Slide 1 – Alternative Station Location at Albert College Park

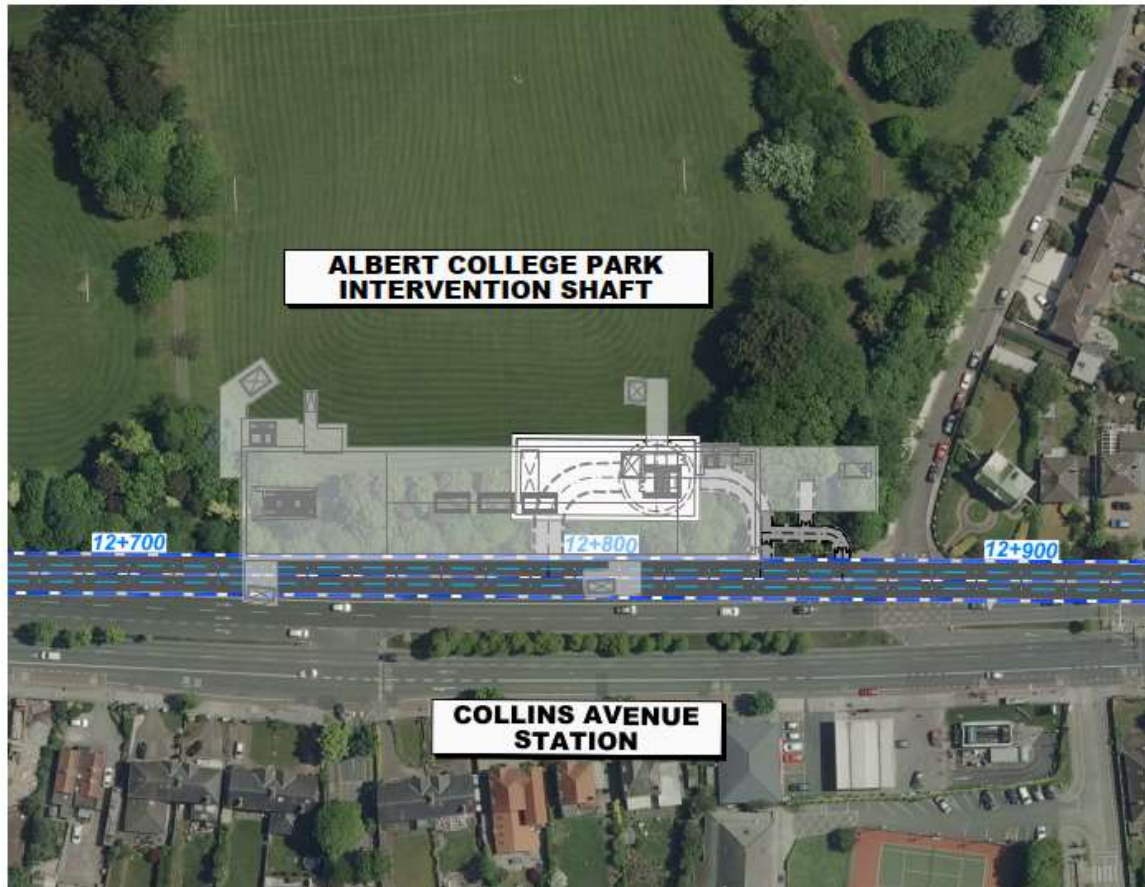
2	Third and fourth paragraph	1	<p>If the station were relocated to Albert College Park, as outlined above, the ventilation shaft could be located at a vacant site adjacent to Ballymun Library directly along the Metrolink route. Residents in the area, in particular the representative Resident Associations, have actively engaged with every stage of the consultation and feel very strongly that alternative locations for the station and ventilation shaft have not been adequately considered. While work on the station, if located in the park, will put several playing pitches out of commission for the duration of the build, and will cause disruption to park users and its wildlife, the location of a shaft, proposed carpark and access for emergency vehicles will also cause disruption whereas a similarly designed station as the Griffith Park Station would minimise the impact on the park with far less permanent land take than the proposed ventilation shaft.</p>	<p>Please refer to response (1) that explains the rationale for the proposed location of Collins Avenue Station and thus the intervention shaft.</p>

4	Conclusion	2	<div>I agree with and wish to support submissions from local resident associations: GADRA and ARCA(&Ballymun Road North Residents). The relocation of the station to Albert College Park and the ventilation shaft to empty land beside Ballymun library is a positive option from both short term and long term objectives. Short term advantages: Less adverse impact on traffic on surrounding roads Less adverse impact on OLV Schools Removes risk of Seniors having to vacate homes at Albert College Court and Hampstead Court Long Term advantages: Smaller station footprint with less adverse impact on surrounding area Less land take from Albert College Park More convenient for those accessing DCU (largest driver of passenger movement at this stop) Less risk of impeding/changing flow of underground river Wad = less risk of flooding for Ballymun Road residents Retains OLV church frontage and architectural appearance</div>	<div>TII have set out in the above responses the rationale for the proposed location of Collins Avenue Station and hence the need for an intervention shaft south of the proposed Collins Avenue Station, including the preferred location for this shaft in Albert College Park, and the environmental mitigation measures that will be employed to mitigate temporary environmental impacts, including traffic management and access, noise and vibration and air quality. TII would also like to confirm that the environmental impact assessment undertaken does not indicate a risk of Seniors having to vacate homes at Albert College Court and Hampstead Court as suggested.</div>
